SUBMISSIONS REPORT

SSDA-8865 Mod 1
St Anthony of Padua Catholic
College

Prepared for
SYDNEY CATHOLIC SCHOOLS
3 August 2021

FUTURE

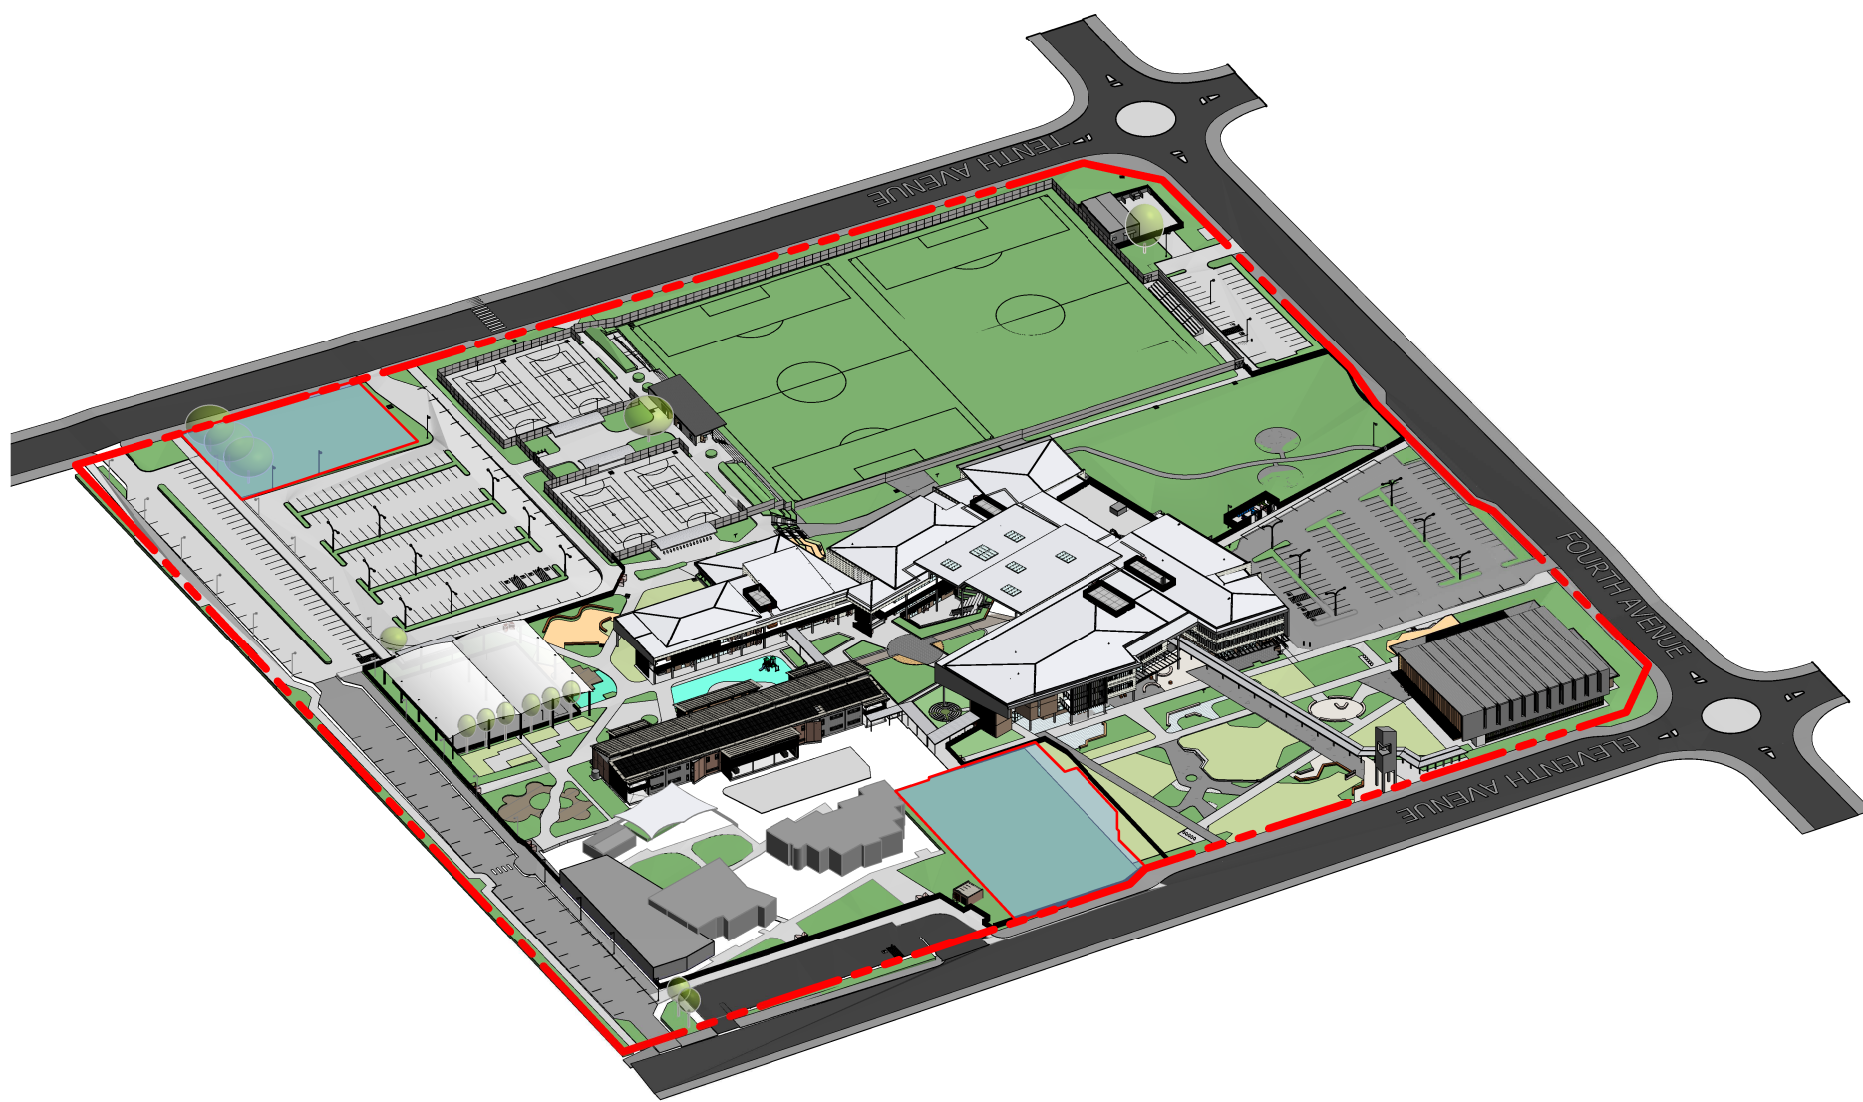
Issue	Referral comment	Response to submission
4.	- why the approved 'Phase 1' and proposed 'Existing' figures differ, as indicated in proposed Condition B8 Table 1. For example, the 'Existing' figures show a reduction in both car and bicycle parking spaces when compared to the previously approved 'Phase 1'.	The carparking and bicycle parking numbers approved as Phase 1 were intended to reflect the existing parking and bicycle provision on the site and should have been identified as 'existing' rather than 'Phase 1'. Since the SSDA approval and the engagement of a new project architect the proposed carparking layouts have been refined. While the approved total number of car parking and bicycling spaces has not changed, they have been distributed slightly differently across the site. With the reduction in the number of phases, the majority of carparking will be delivered in Stage 1. Stage 1 is under construction and the site currently provides 66 car parking spaces, 42 drop off spaces and 10 bicycle spaces.

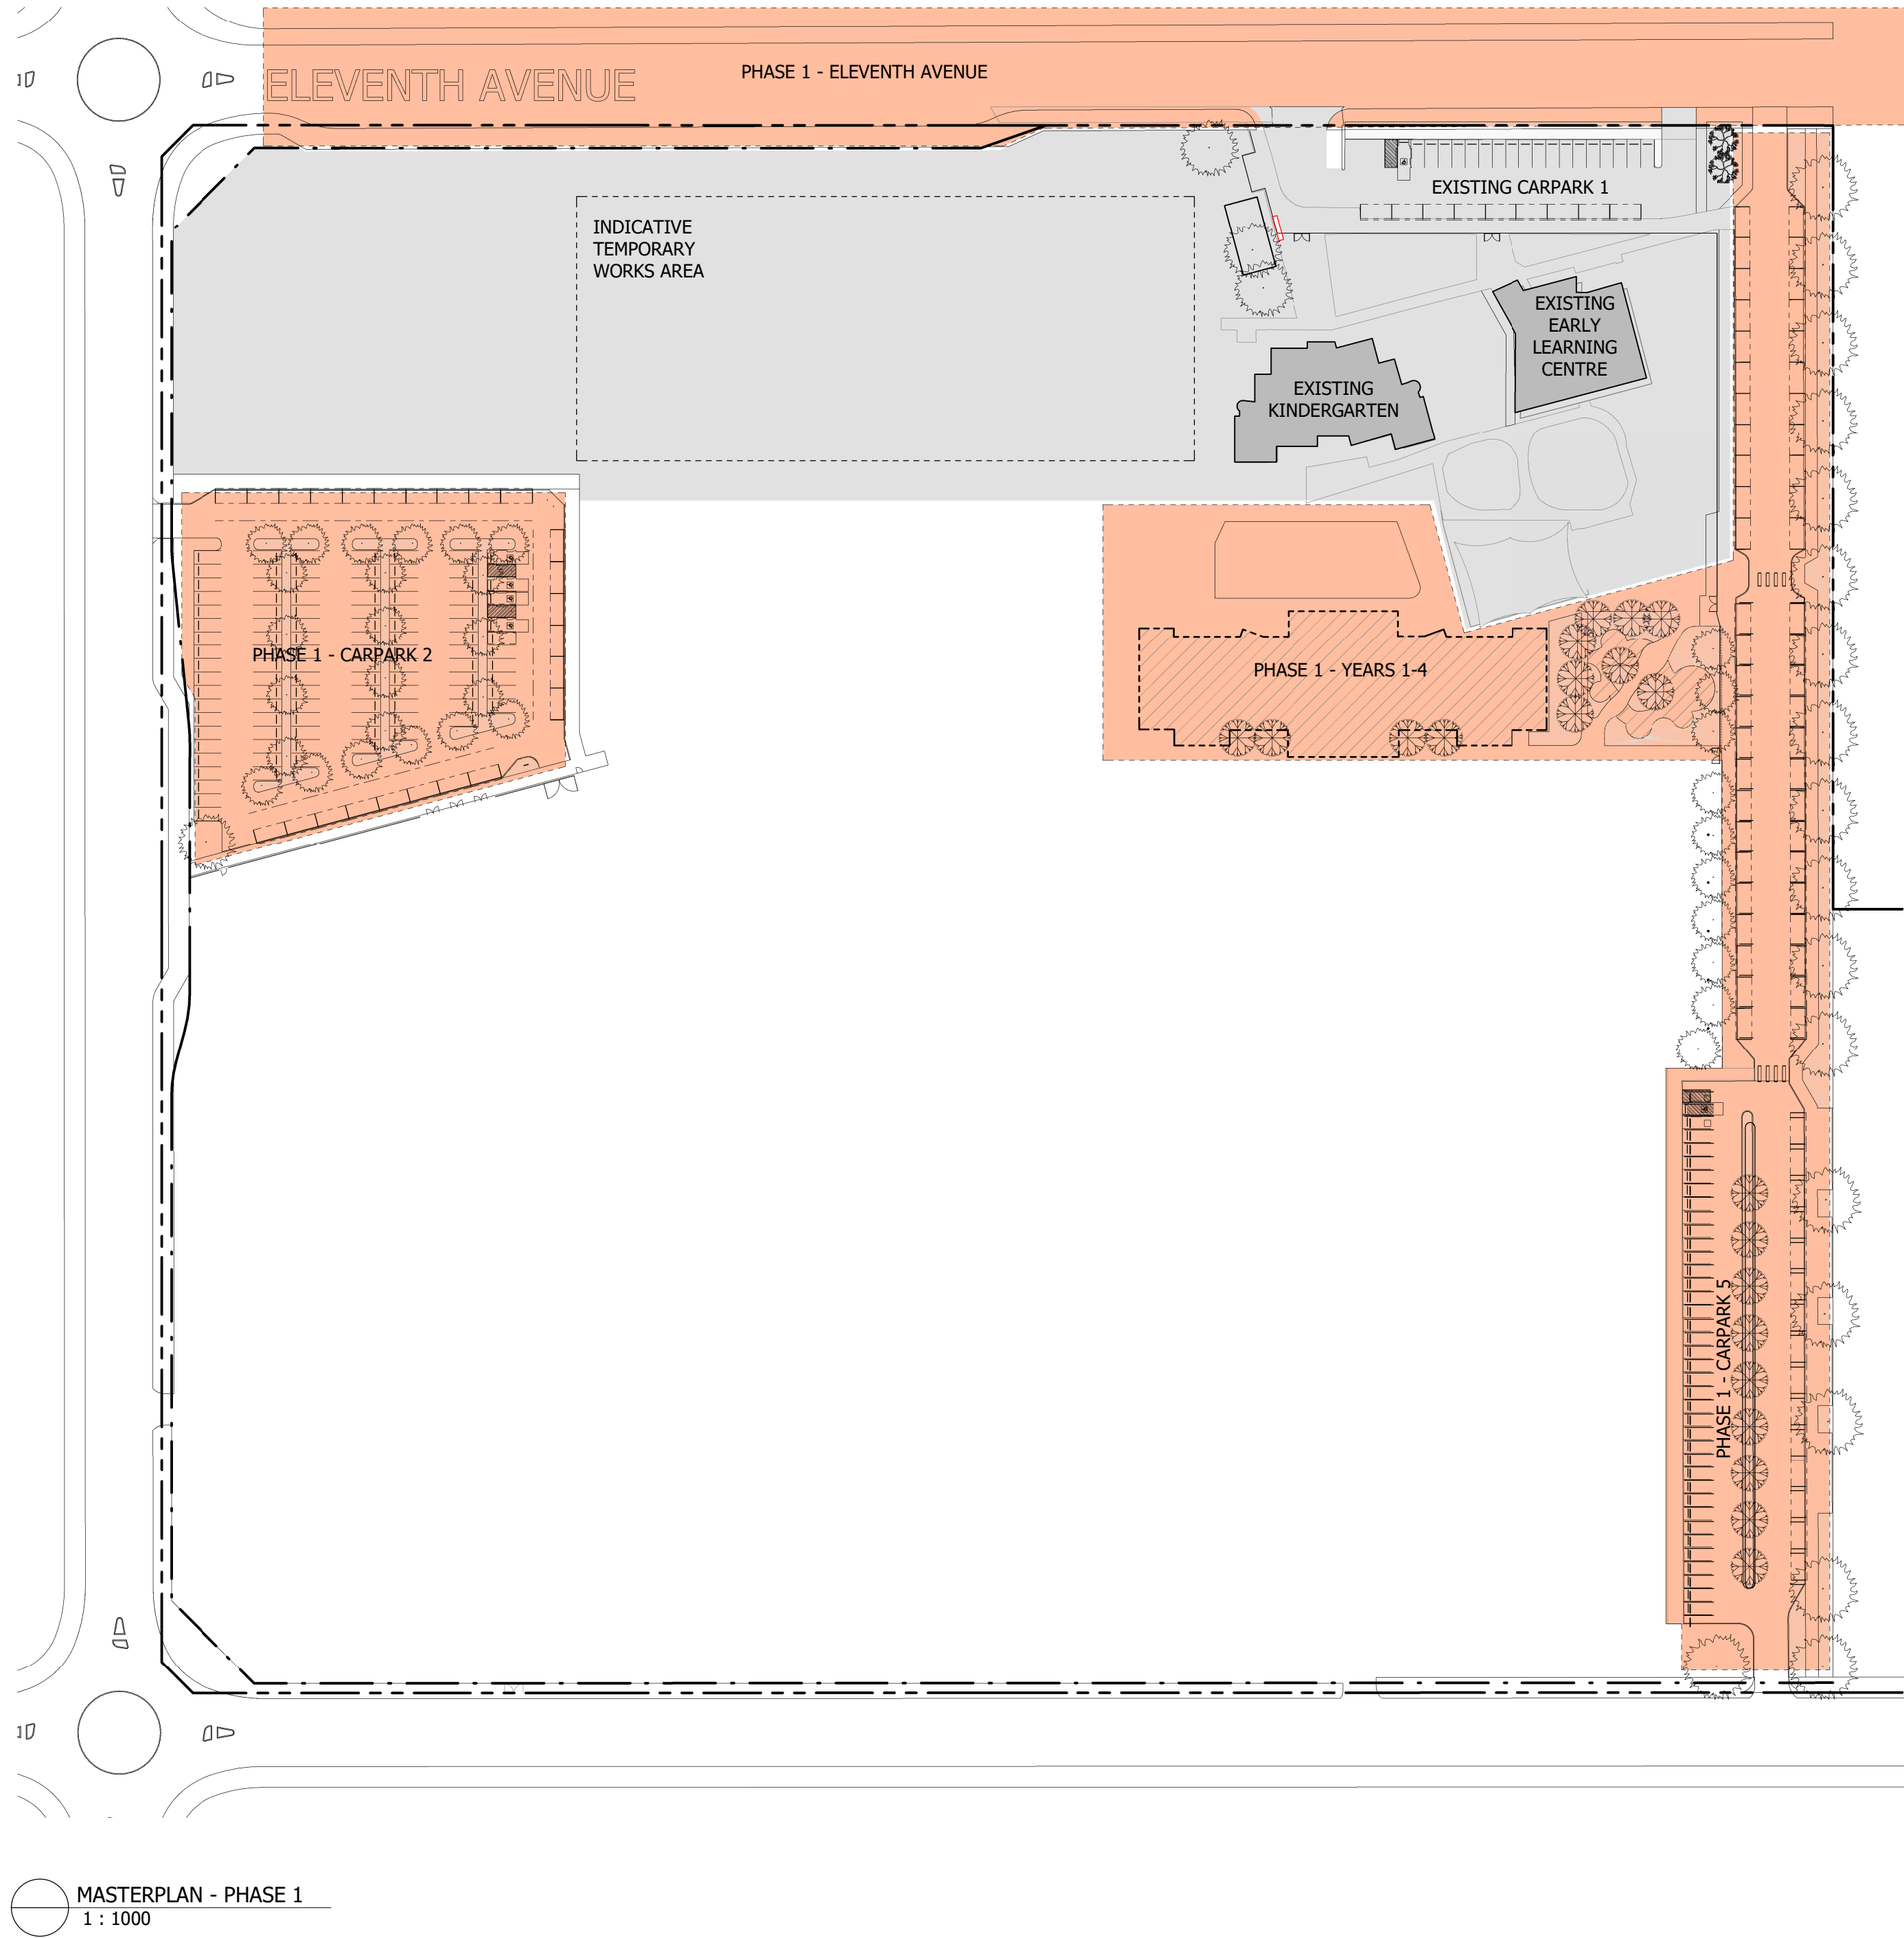
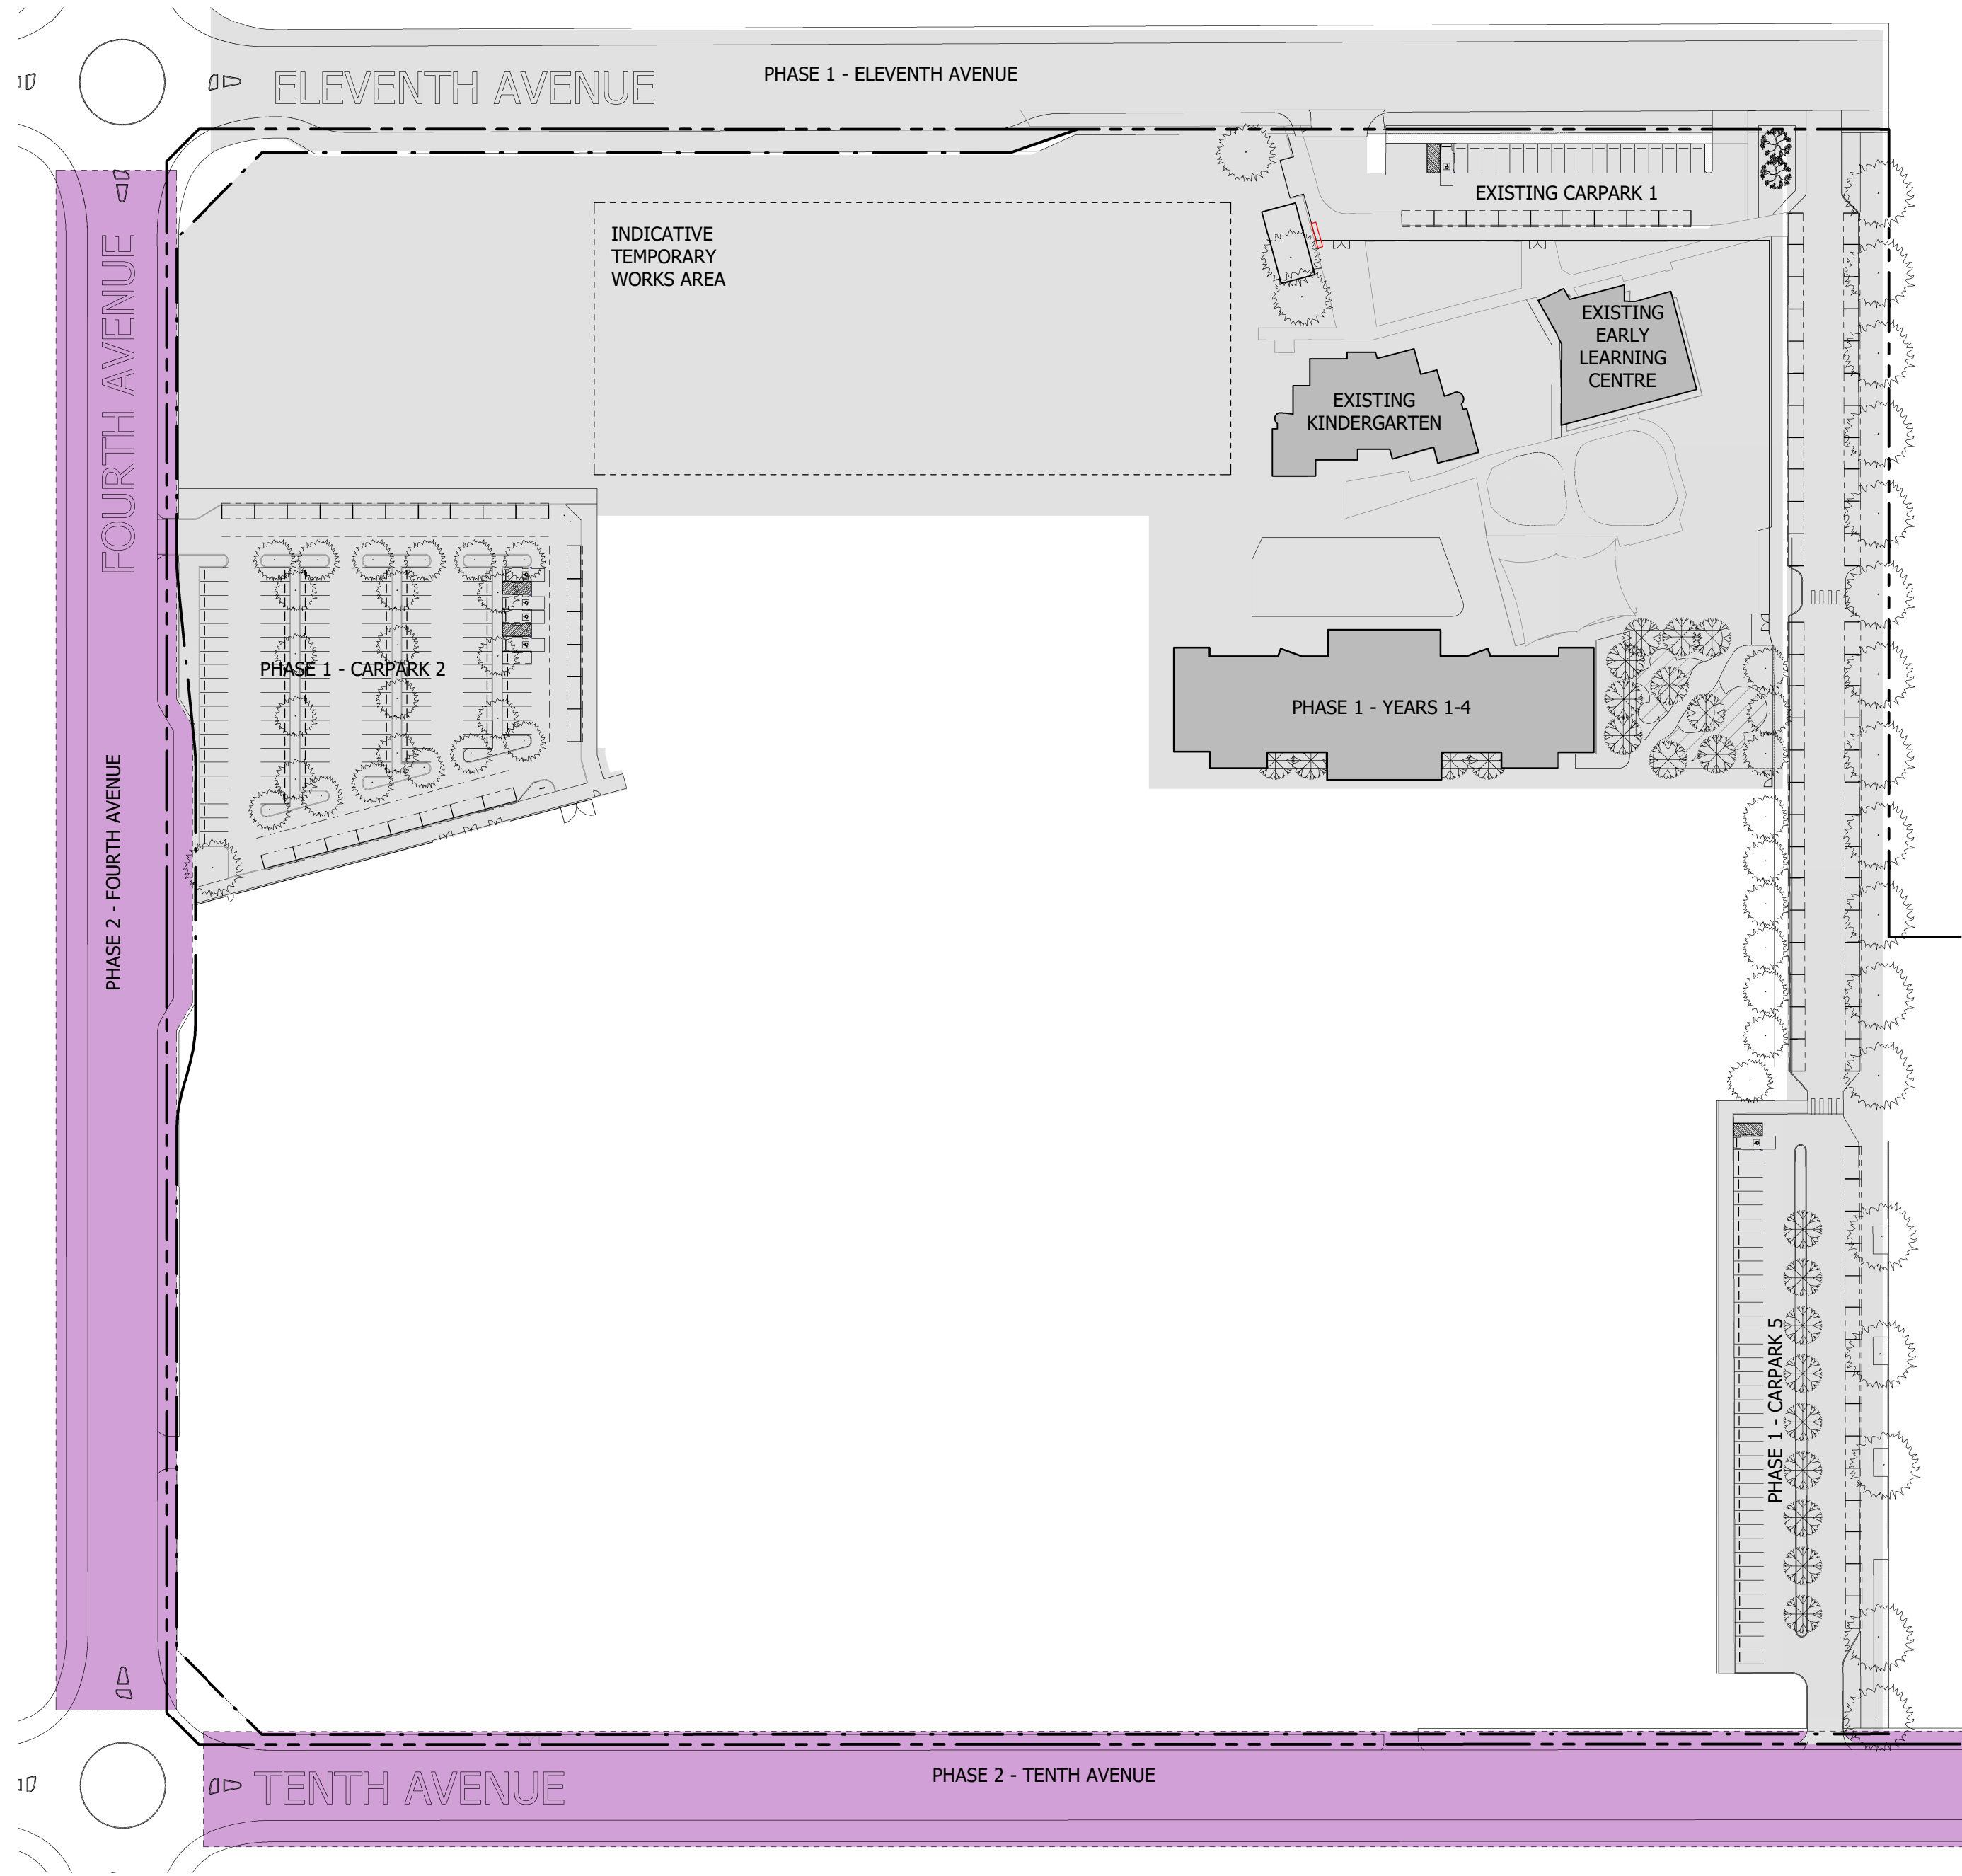
3.	- why the Year 1-4 building, as depicted in the proposed staging plan, is shaded in grey	This error has been corrected in the updated plan set. The Years 1-4 building is part of Stage 1 and is shaded orange. Refer to amended plans at Appendix A.
